**Re: Response to Biodiversity Development Assessment Report comments from
Council for Wyong Hospital Expansion Planning
14-15, 664 Pacific Highway, Hamlyn Terrace**

I refer to correspondence received from Central Coast Council (1 April 2019) with respect to the Biodiversity Development Assessment Report (BDAR), our ref# 18COLL02BDAR for the proposed Wyong Hospital Expansion.

DRAWING NAME
TREE REMOVAL / RETENTION
PLAN B

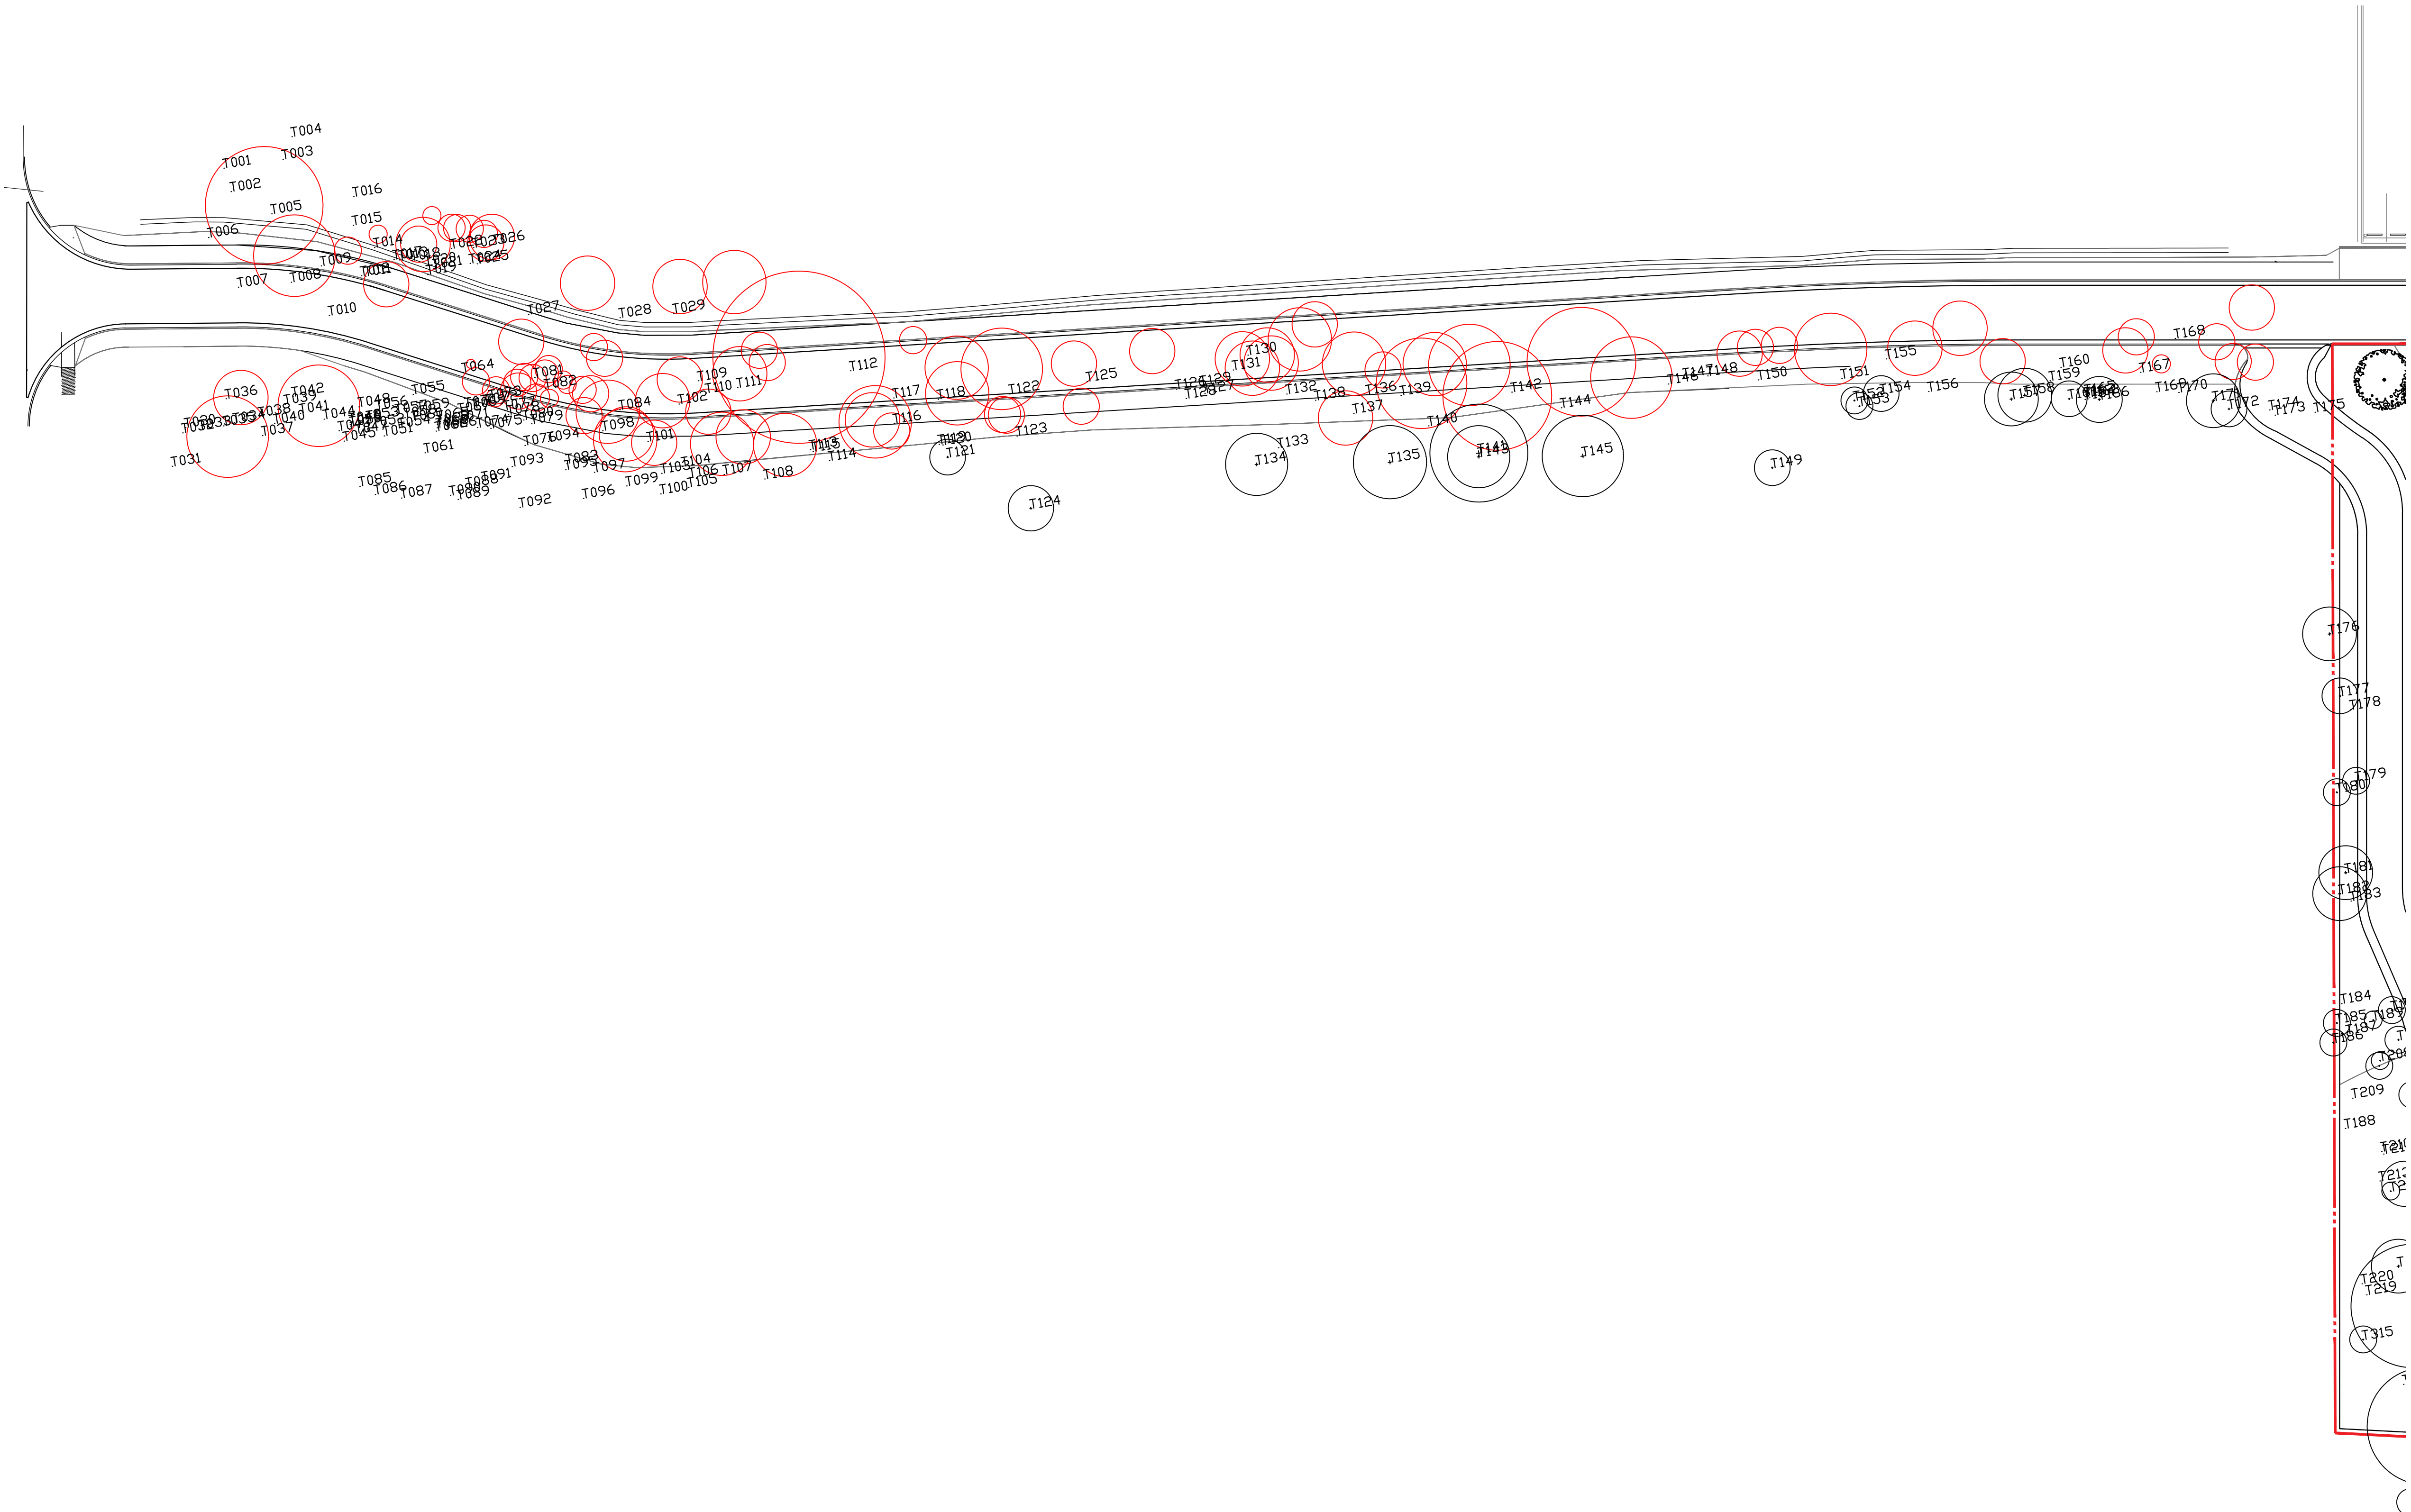
Council is unable to verify if the patch size for each vegetation type has been determined and entered correctly into the calculator as this information is missing from the vegetation integrity assessment (refer to Section 5.3.2 of the BAM).	The patch size used in the calculator was 1,000ha. It has been entered correctly into the calculator. The patch size area is assigned to the vegetation zone as a class, being <5ha, 5–24ha, 25–100ha or ≥100ha. Anything greater than 100ha is	The vegetation integrity assessment has been updated with a description of the patch size classes and which category it falls into. Patch size is identified within the landscape plan and found in

Issue	Response	Action required																								
	treated the same. The patch size is large as there is extensive connectivity in the locality through Hamlyn Terrace through to the Wadalba Wildlife Corridor, and the swampy wetlands in Tuggerawong, Tacoma and Wyong. It also extends to the north-west through rural residential areas of Warnervale, Woongarra and Halloran.	table 1.2 and figure 1.4, for the 1,500m assessment circle. The assessment circle has been added to the updated BDAR. The 1500m assessment circle is a buffer to the site. The 1000ha is referring to the patch size. Therefore, two different entities																								
The summarised table of plot data used to determine the current vegetation integrity scores for each vegetation zone is missing (refer to Section 5.4.1.2 of the BAM).	A summary of the derived scores at the end of Section 3.1, in table 3.3 and 3.4 of the BDAR.	Screen shots have been inserted below to show all vegetation integrity score entries, or tabulate further the breakdown of each composition, structure and function score as shown in the calculator.
